Reference No:	2025/62/91652/E
Site Address:	3, Alpine Close, Batley, WF17 7PN
Description:	Erection of single storey front and rear extensions with front and rear dormers
Recommending Officer:	Faiza Bano

HOUSEHOLDER DELEGATED REPORT

Application Number	2025/91652
Location	3, Alpine Close, Batley, WF17 7PN
Proposal	Erection of single storey front and rear extensions with front and rear dormers
Publicity end date	10 th July 2025
Number of representations received	None.
Kirklees Local Plan Allocation/Designation	LB Airport Consult, DEVELOPMENT_LOW_RISK_AREA
Extension to Time (EoT)	Yes – 10th October 2025
Recommendation	Conditional Full Permission

DRAWING TITLE:
GROUPED PLANS

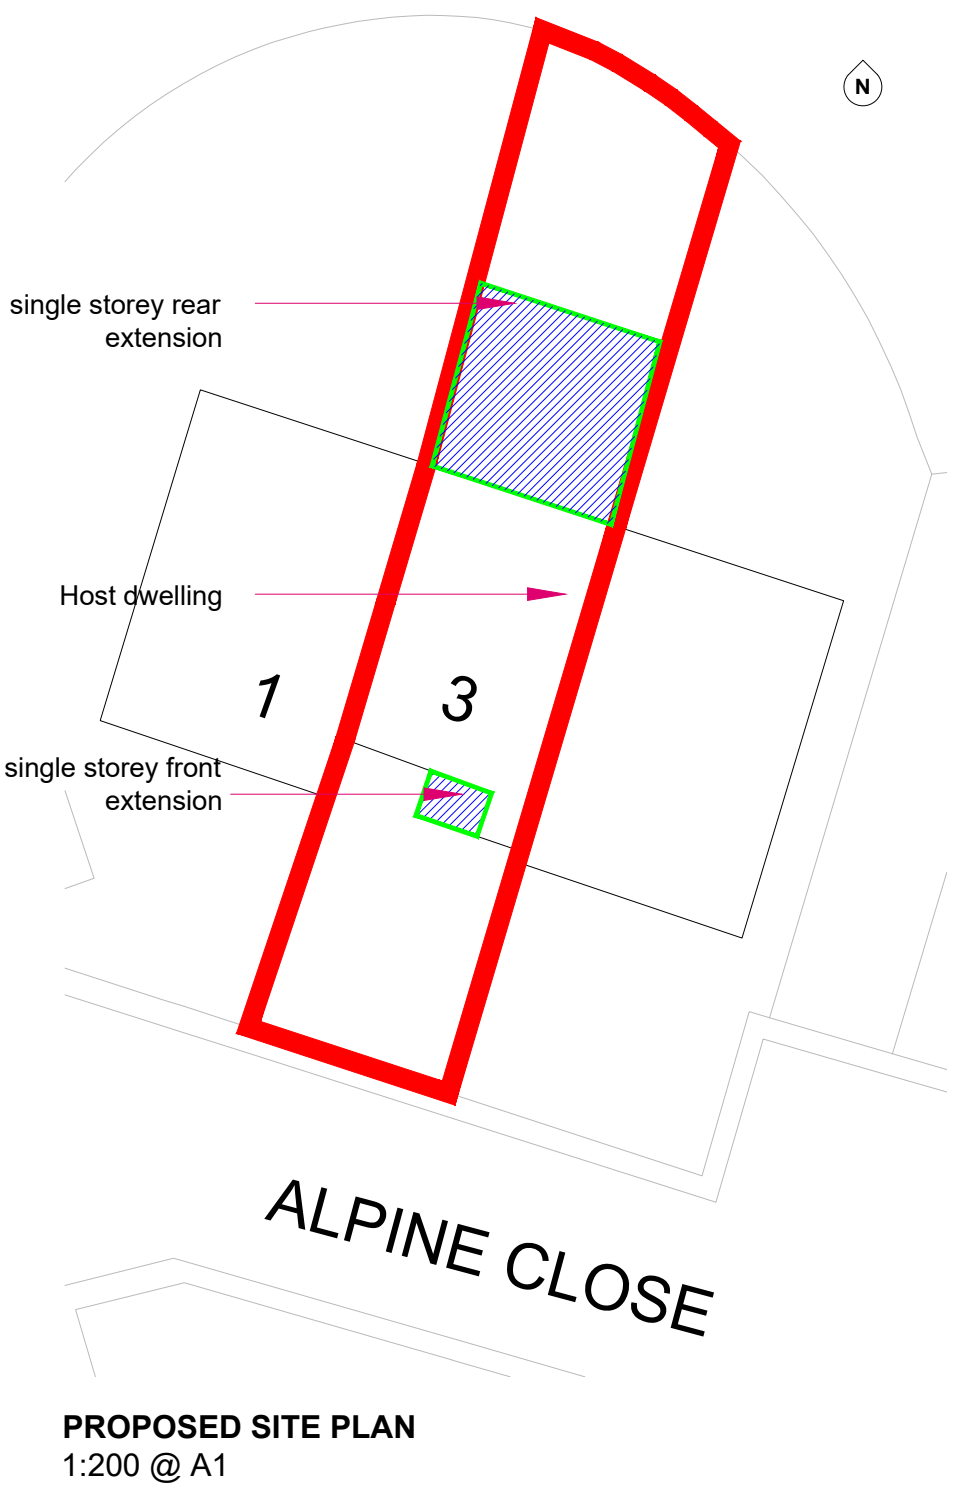
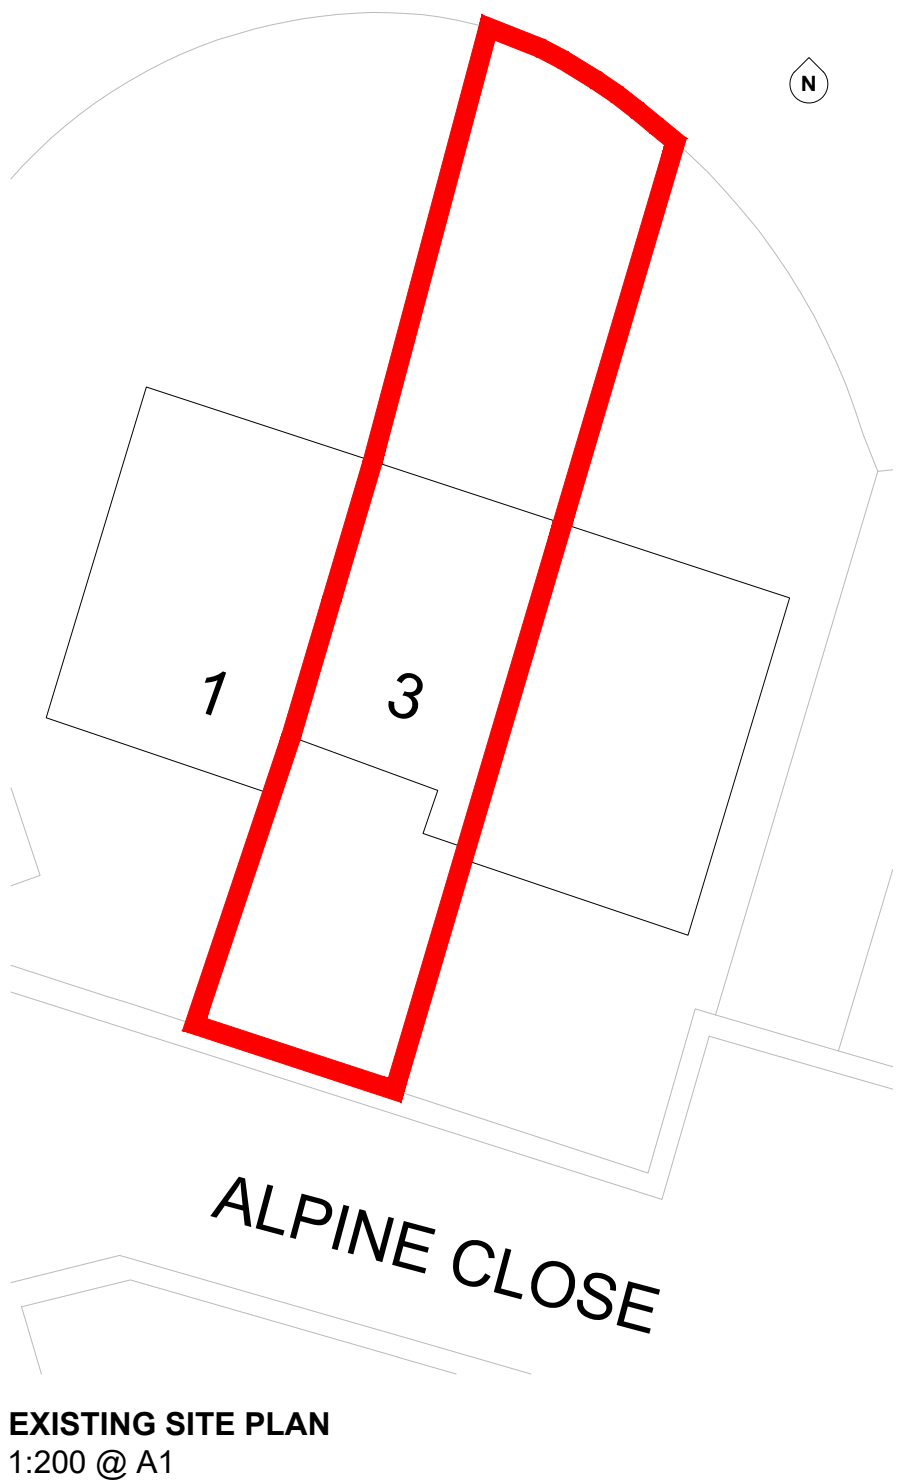
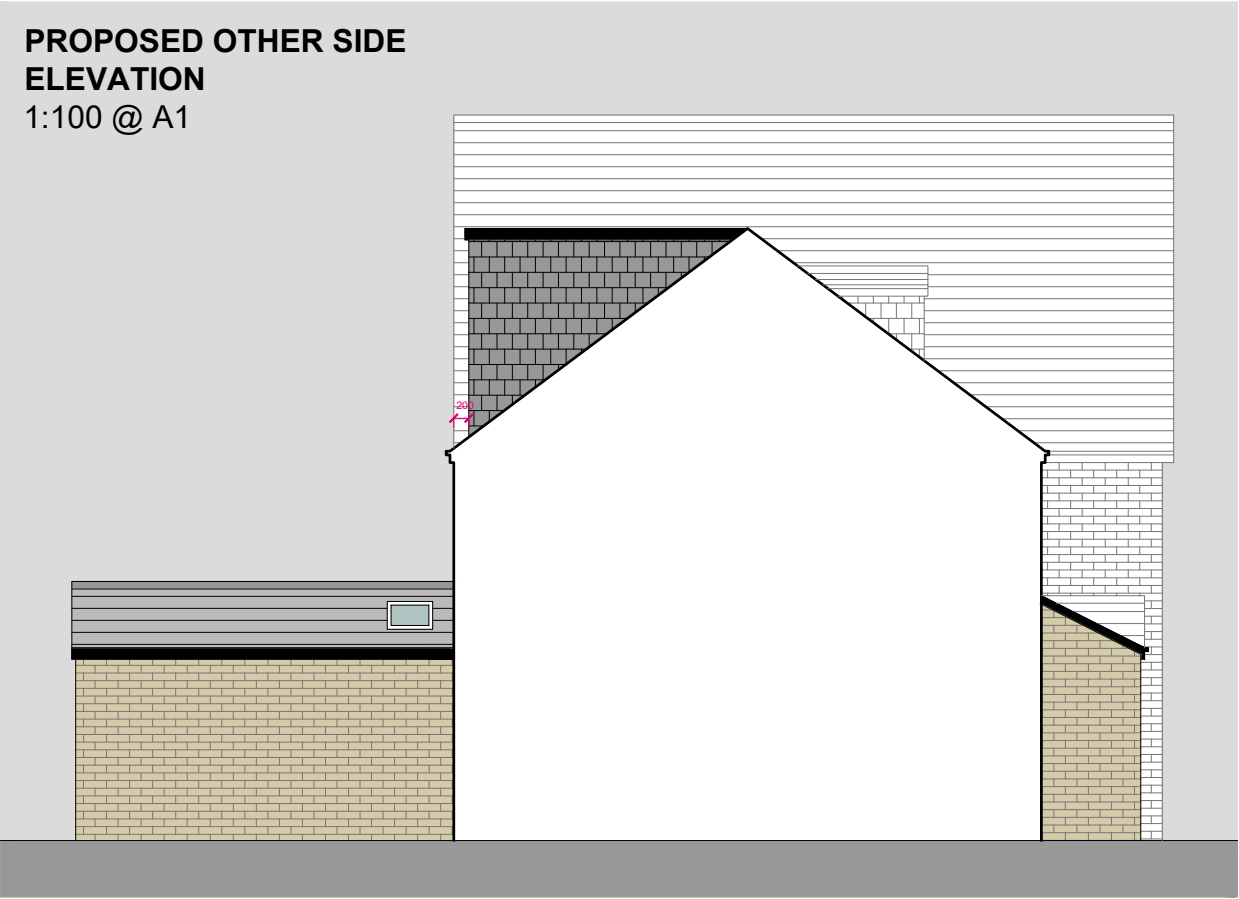
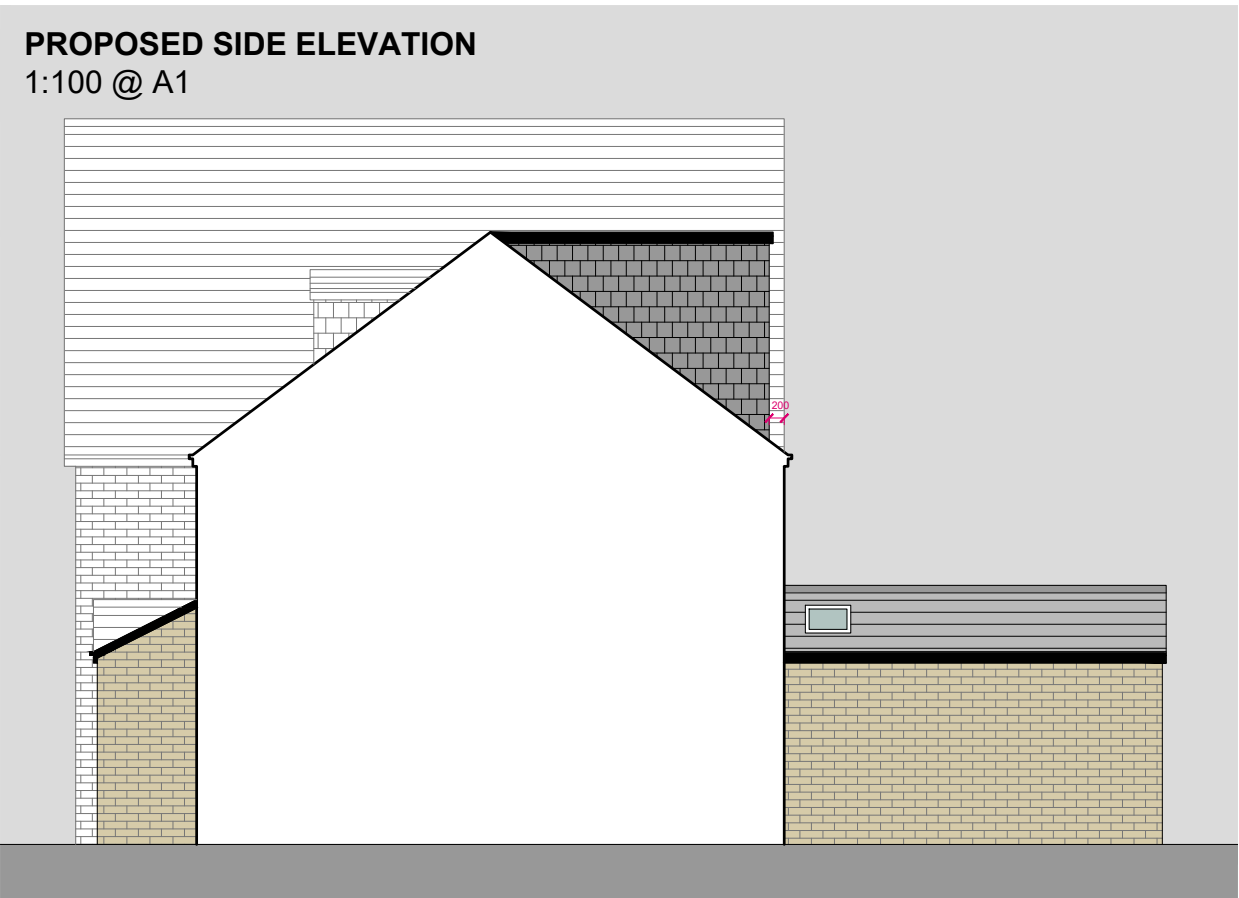
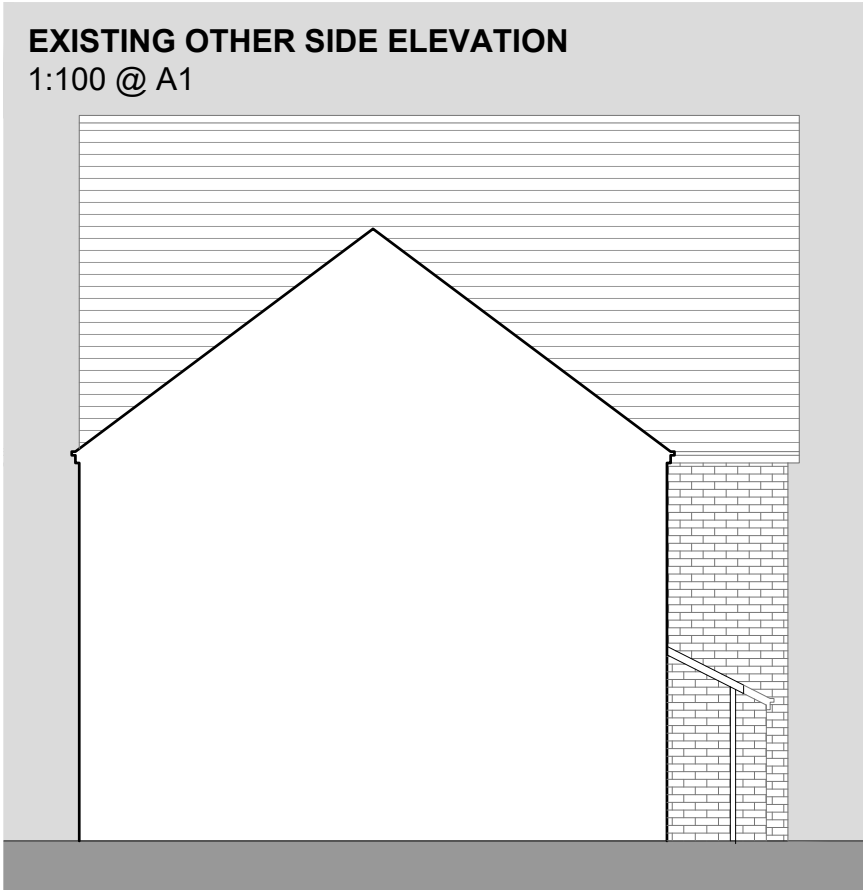
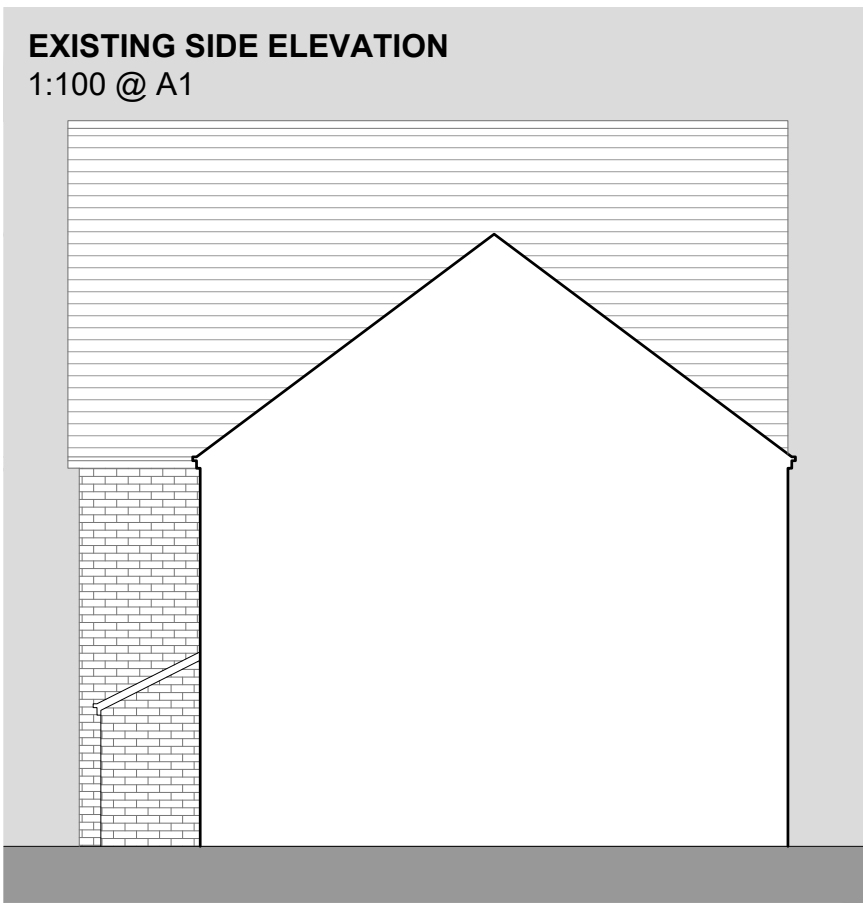
respect the original house and garden in terms of its size and scale	Yes – the extension does not cover more than half of the total area around the original house.	
use appropriate materials which match or are similar in appearance to the original house; and	Yes – to match existing	
not have an adverse impact by way of overshadowing or loss of outlook of neighbouring properties.		The extension projects out by 5m, however, this application has a prior approval fallback in place.

Single storey extensions should:	<u>Yes - COMPLY</u>	<u>No - JUSTIFY</u>
be in keeping with the scale and style of the original house;	Yes – The extension is designed to be in keeping with the scale and style of the original house. It uses matching materials and architectural features, ensuring it blends seamlessly with the existing structure.	
not normally cover more than half the total area around the original house (including previous extensions and outbuildings);	Yes – The extension does not cover more than half the total area around the original house	
not exceed 4 metres in height;	Yes – the extension has an overall height of 3.5m.	
not project out more than 3 metres from the rear wall of the original house for semi-detached and terraced houses or by 4 metres for detached properties;		No – the extension projects out by 5m. This is considered acceptable given that there is a PD fallback.

where they exceed 3m in length the eaves height should generally not exceed 2.5 meters; and		No – the eaves height is approximately 2.9m – acceptable for the reasons above.
retain a gap of at least 1 metre from a property boundary, such as a wall, fence or hedge.		No – acceptable due to the PD fallback.

Dormer windows should:	<u>Yes - COMPLY</u>	<u>No - JUSTIFY</u>
relate to the appearance of the house and existing roof;		No – While the proposed front dormers would demonstrate a resemblance to the original dwelling in terms of roof design, the proposed rear dormer does not particularly reflect the proportions or roof form of the host dwelling. However, a rear dormer of a similar scale and massing could reasonably be constructed under the property's permitted development rights. On this basis, significant weight is given to the Permitted Development (PD) fallback, and it would therefore be unreasonable to withhold permission for this element on design or visual amenity grounds.
be designed in style and materials similar to	Yes – Both the front and rear dormers

the appearance of the existing house and roof;	would be constructed in materials to match the existing dwelling including slate cheeks. The front dormers would incorporate pitched roofs, while the rear dormer would be flat roofed, a PD fallback position exists as discussed above.	
not dominate the roof or project above the ridge of the house;	Yes – Proposed dormers do not unduly dominate the main roof nor project about the ridge.	
be set below the ridgeline of the existing roof and within the roof plane; and	Yes - Both the front and rear dormer/s would be set below the existing ridgeline.	
be aligned with existing dormer windows on neighbouring properties in the same roof plane where relevant.		No other dormers in the area so it is considered that in this instance it is not relevant.

- 1 and 3 Alpine Close – these properties are the adjoining terraced dwelling. Given that the number one sits on a higher topographical level and number 5 sits at a lower topographical level, it is considered that there will be some impact in terms of light and outlook. However, a notification for an enlarged dwelling was advertised under application 2025/ 90449 and as a result of this application, no representations were received. No representations for this application have been received either. It is material to note that the applicant benefits from prior approval consent (prior approval not required) for a rear extension of the same scale now proposed, which establishes a realistic fallback position. This extension could therefore be implemented under permitted development rights irrespective of the outcome of the current application. Therefore, there is a permitted development fall back position, which is afforded significant weight in the assessment.

The front dormers are unlikely to cause any significant harm in terms of residential amenity of the adjoining properties given the level at which the works would be sited. The sloped nature of the applicant site and the position within the existing roof is such that there would be no overshadowing.
